Lower Thames Crossing DCO

Gravesham Borough Council

Appendix 1a

Gravesham Borough Council's responses to agenda items for ISH 11 on Environmental Matters – with additional post-hearing notes

*Local Landscape Character Area boundaries of the Kent Downs AONB LCA, West Kent Downs, Sub-areas Cobham and Shorne*

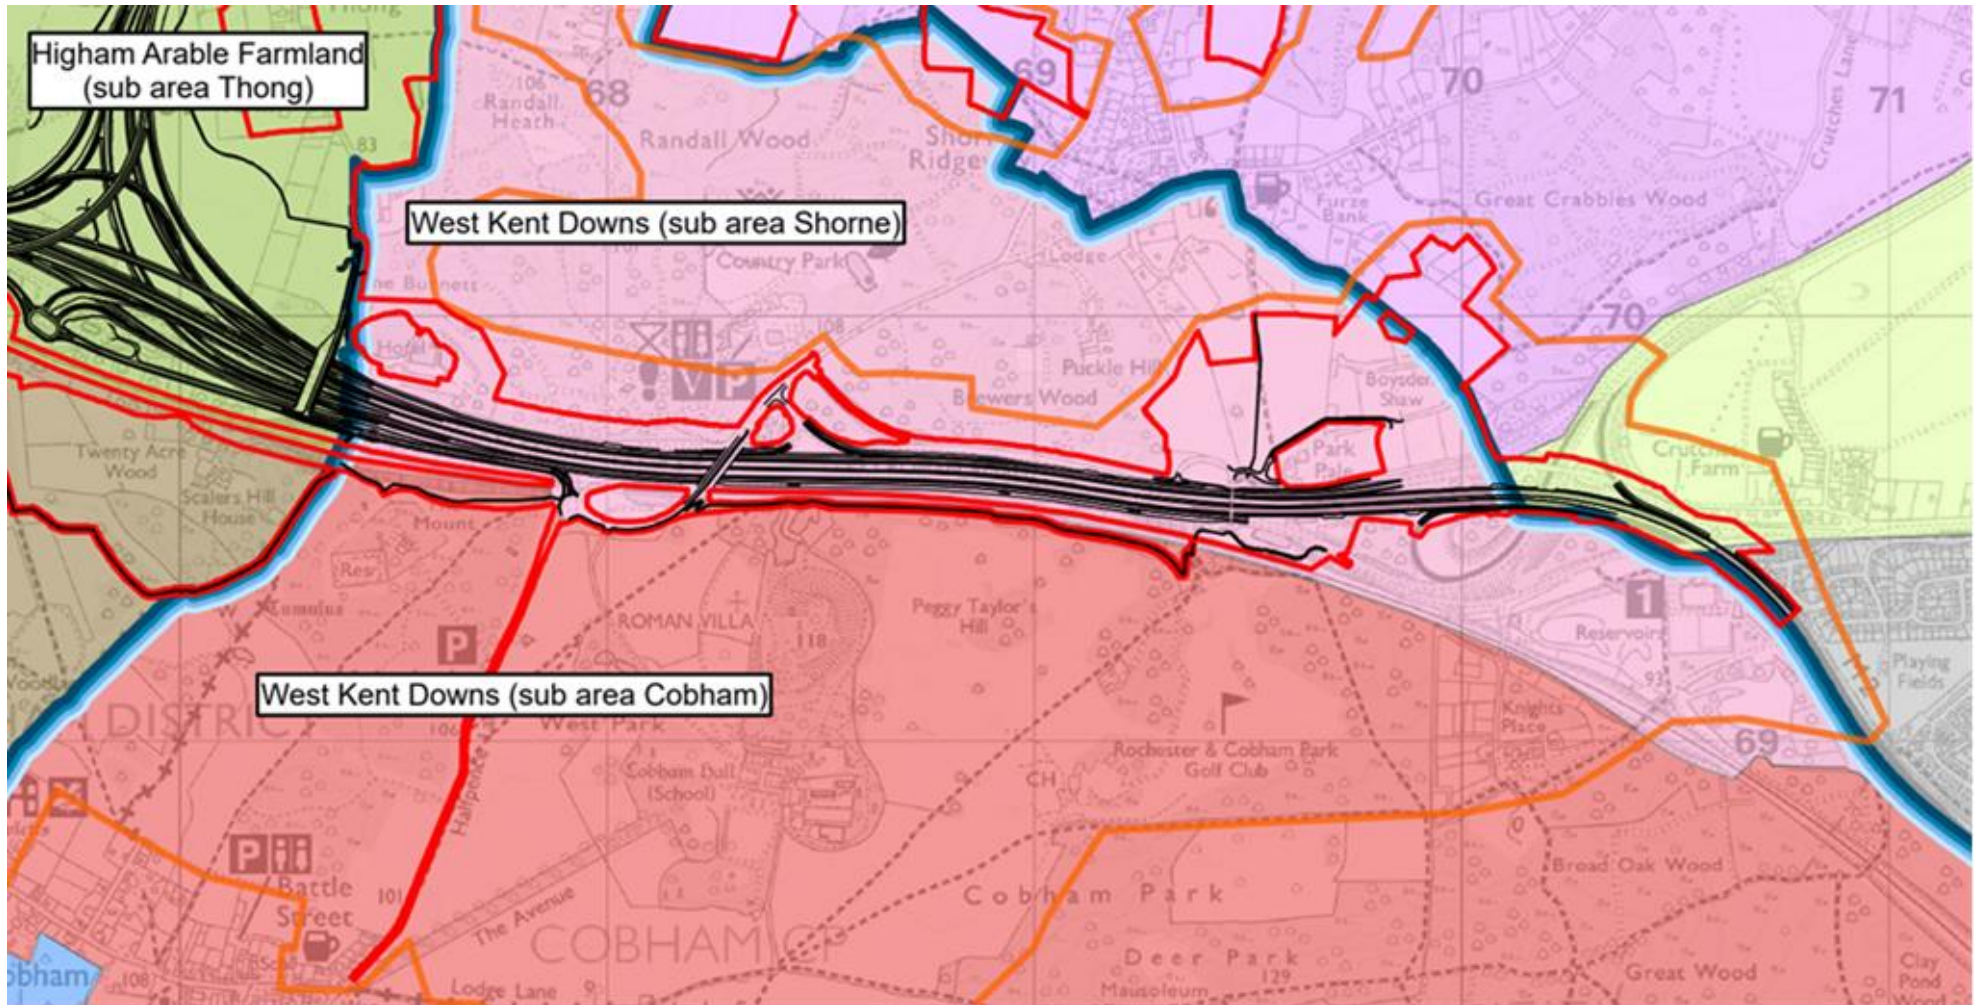
In the documents, the Applicant has adjusted the boundary, moving it further south to the line of HS1 (APP-198 Figure 7.2) The Applicant's LVIA has been based on this adjusted boundary.

In our view, this change in boundary position influences the landscape sensitivity and Magnitude of effect of the proposals on these areas, and this alters the findings of the landscape assessment of these LLCAs, assessed individually and in a combined assessment.

The original LLCA boundary would place the central reservation of the A2 and the planting along the northern edge of HS1 area within sub-area Cobham LLCA. These areas would be lost as a result of the project, which would have a direct - and more adverse - effect on the LLCA. In this case we believe the Magnitude and nature of effect would be assessed as greater than has been reported in the current assessment documents, during both construction and operation. The Landscape Sensitivity of the Cobham sub-area would be greater, and its Susceptibility to change (by the proposal) would also be greater.

The Shorne sub-area would be similarly affected by the proposals, with major works along the A2, a permanent reduction in tranquility, loss of woodland and a permanent increase in the prominence and scale of the A2 corridor. For these reasons we think the Magnitude and significance of effect at Design Year (at operation) would be assessed as greater than has been reported in the current assessment documents.
